Sent: 28 May 2015 22:13

Subject: Planning Application: K14/15/HH: Broadbeach, 39 Coastal Road, BN16 1SN

1419 SK01A
Broad Beach 1:100
Proposed Ground Floor Plan
January 2015

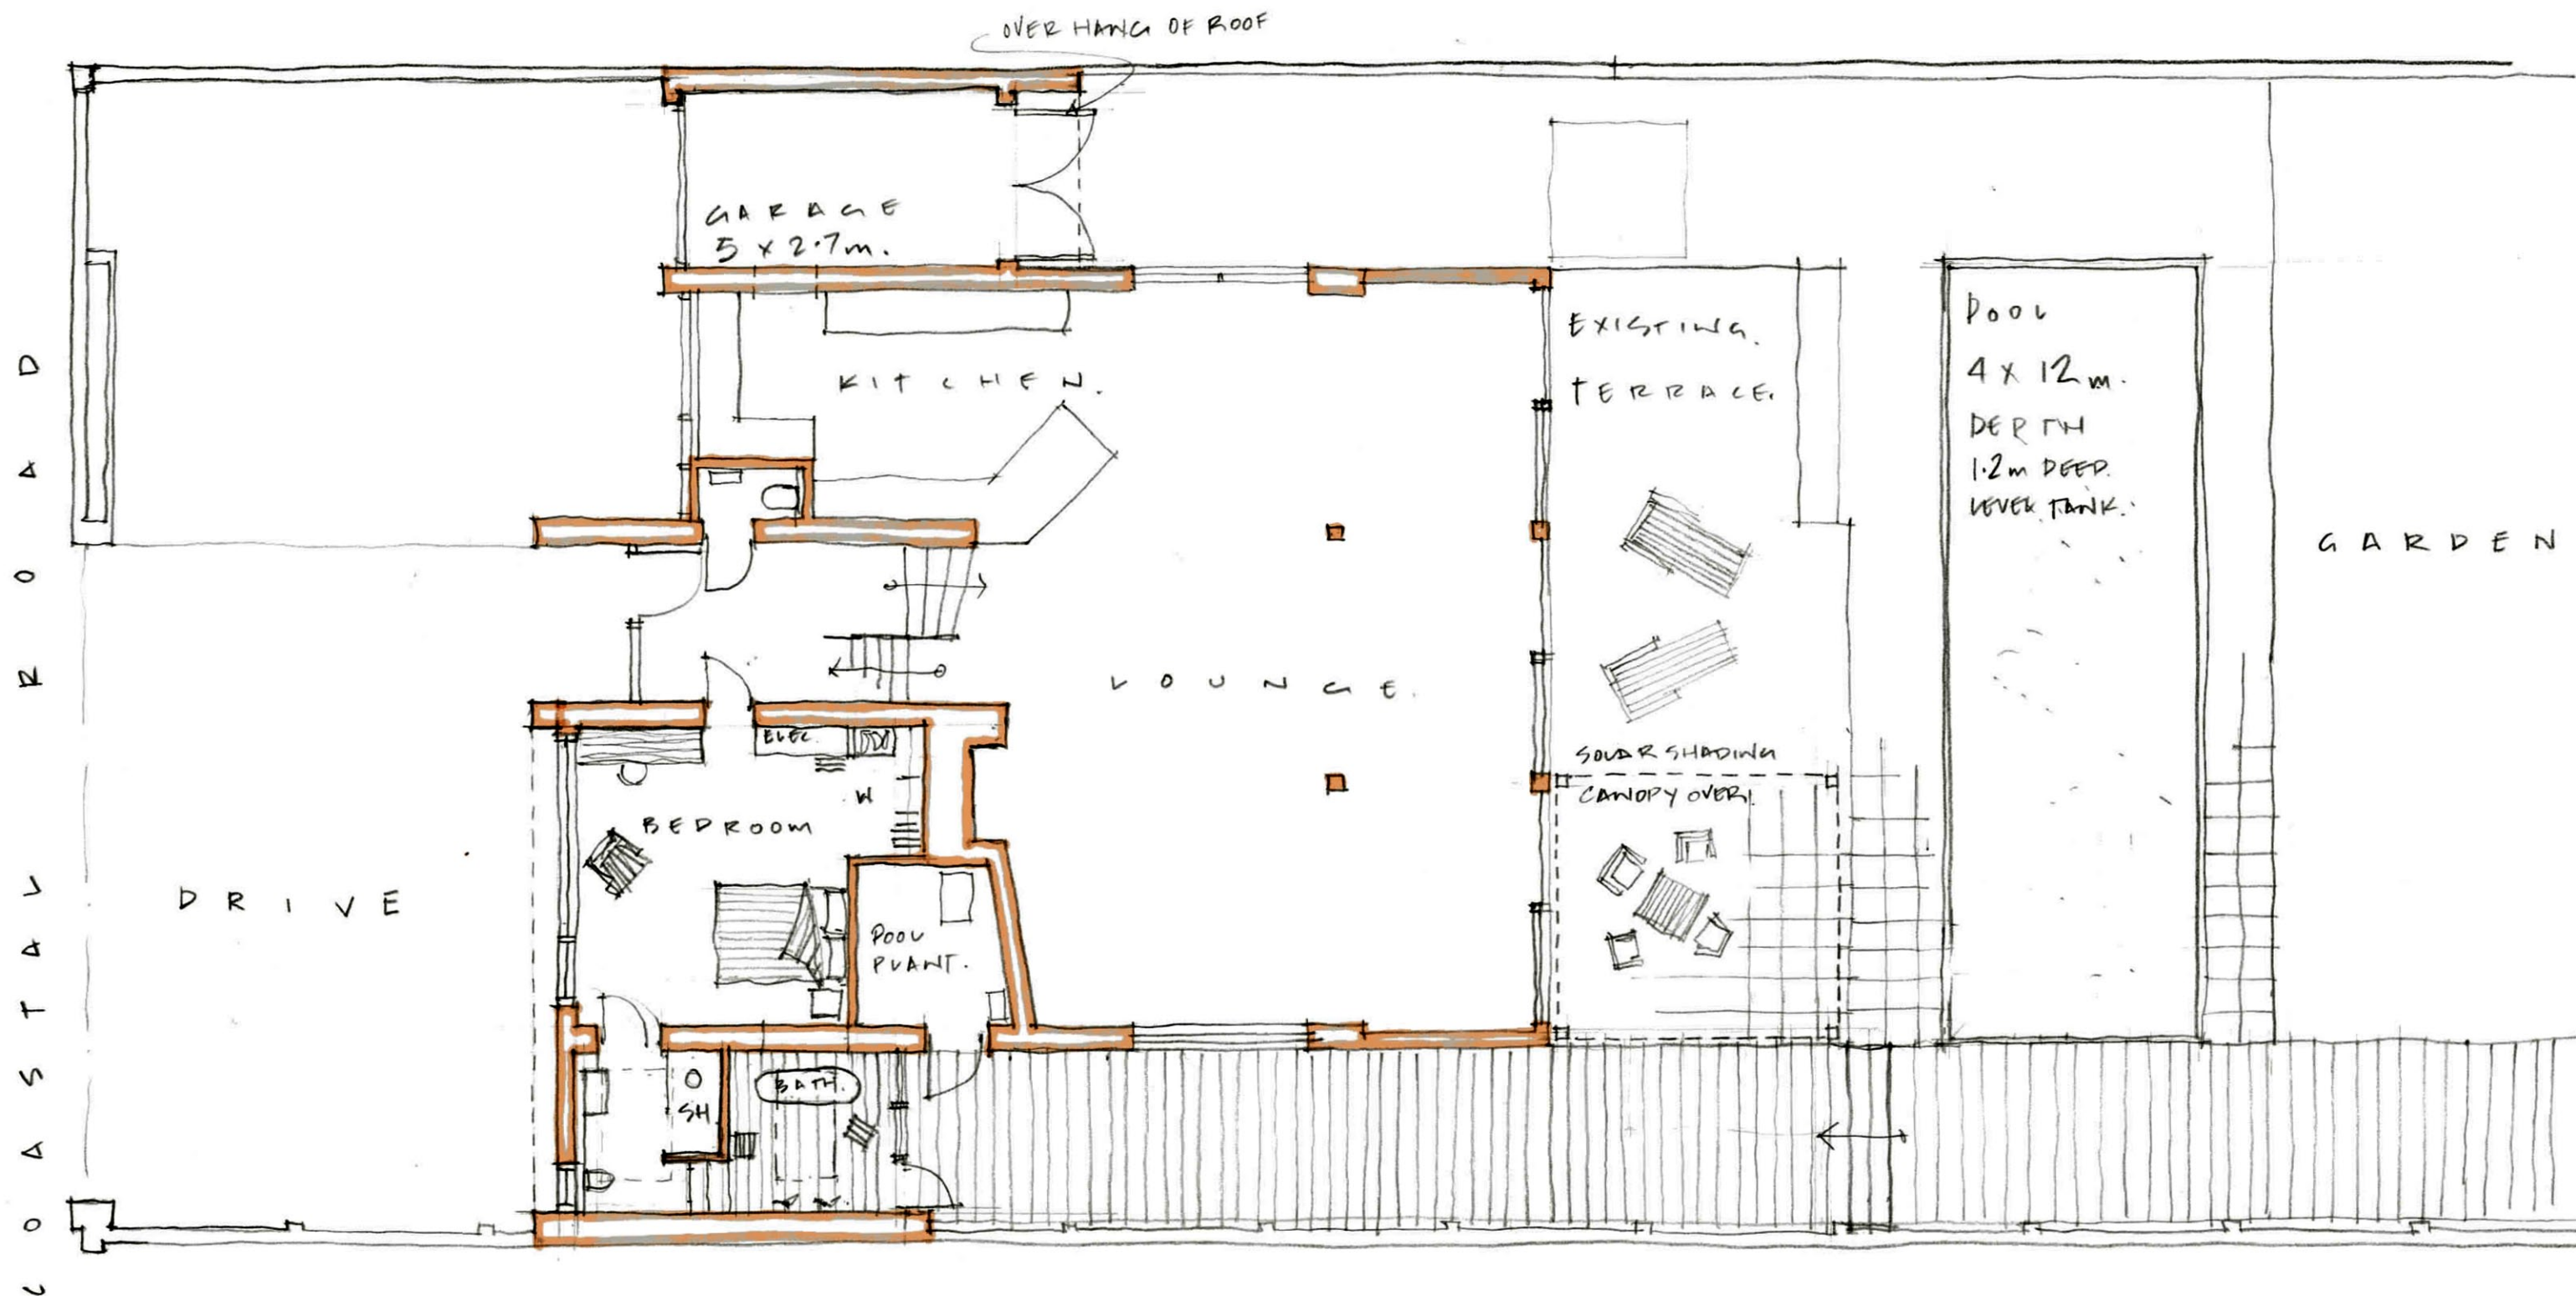
the proposal to build wall-to-wall across the width of the plot at ground floor level when only 2 properties on Coastal Road have done this (i.e. 97% of properties have not) and these 2 properties have placed garages at either side of their plot and not living accommodation. As stated in our objection, we do not understand why it is felt to be reasonable to put living accommodation directly up against the wall of a neighbouring property when no other house in the road has done this (and we have walked the length of the road to validate this point).

1419 SK09A

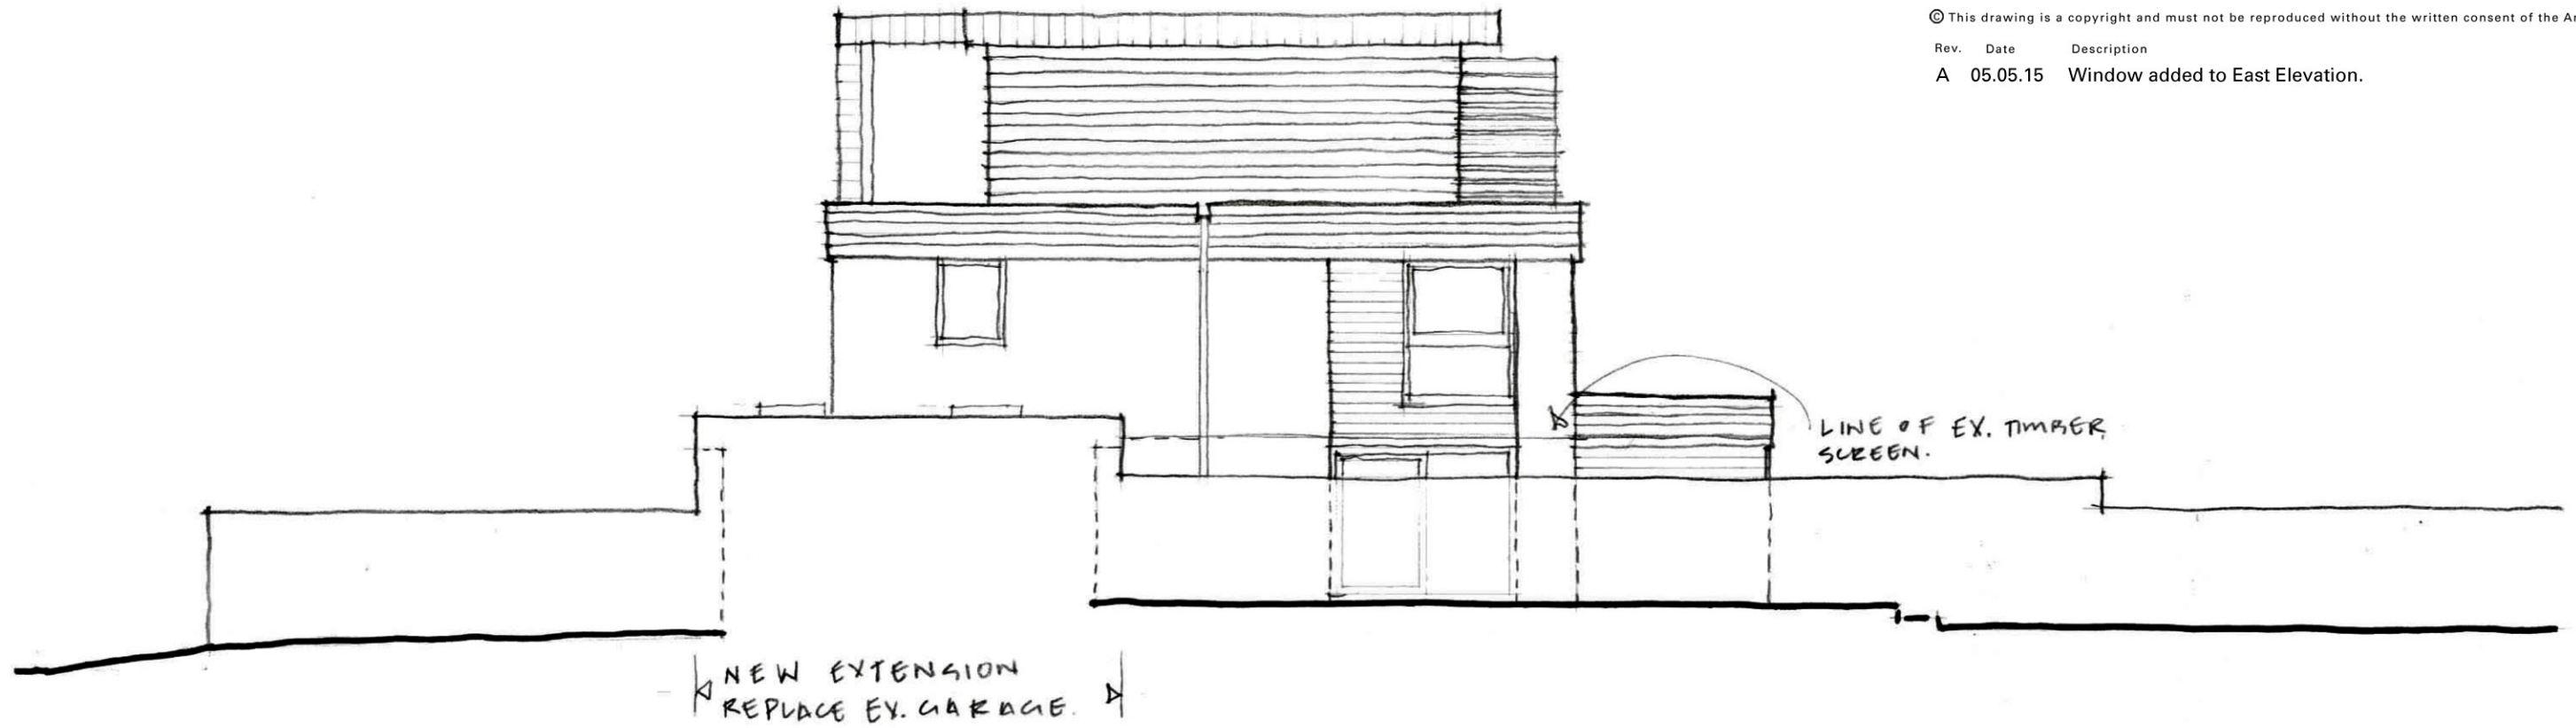
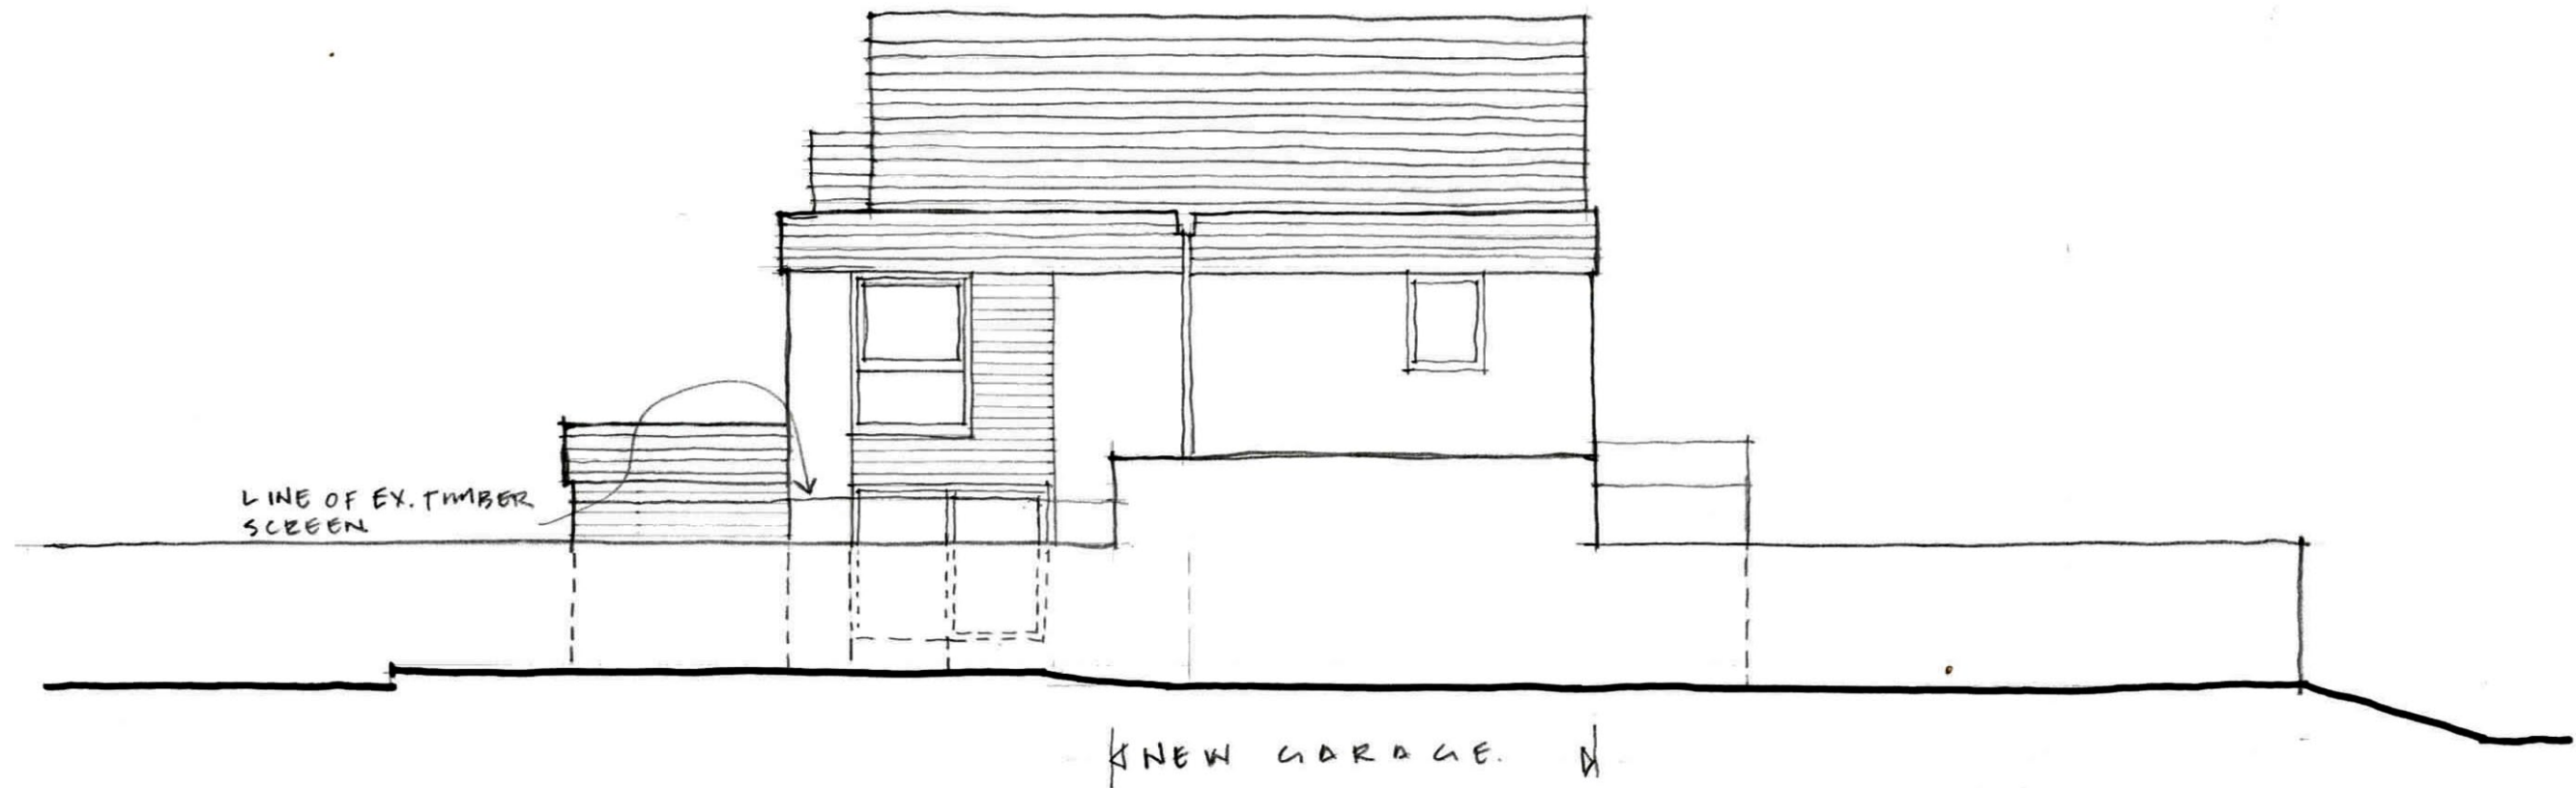
- Our statement that the new extension which is directly against our adjoining wall "*would protrude 1.5 metres above the adjoining wall*" has been described as "*incorrect*". We calculated this from the measurements shown in the architect's drawings and showed the calculation in our objection but there is no explanation as to why this is wrong. However, the key point is that the architect's drawings show that there will be a considerable protrusion above this wall and we have not received an adequate response to this concern. Instead, there is a confusing statement about "*an adjoining false tiled pitched roof on the side of Nr 41*". To clarify: this is decoration along the top of our wall, it does not protrude above the dividing wall, and the nearest point of our property is 10 feet from that dividing wall in line with common practice along Coastal Road and the covenants on our property.

- There is a statement that "*the gap [between Broadbeach and neighbouring properties] is unaltered at first floor level and above, which is consistent with good design and planning practice*" and this point is repeated later in the response. This seems irrelevant because none of the 65 properties along Coastal Road has a first floor or above which is directly up against the boundary of a neighbouring property. Our concern isn't that at all: it concerns
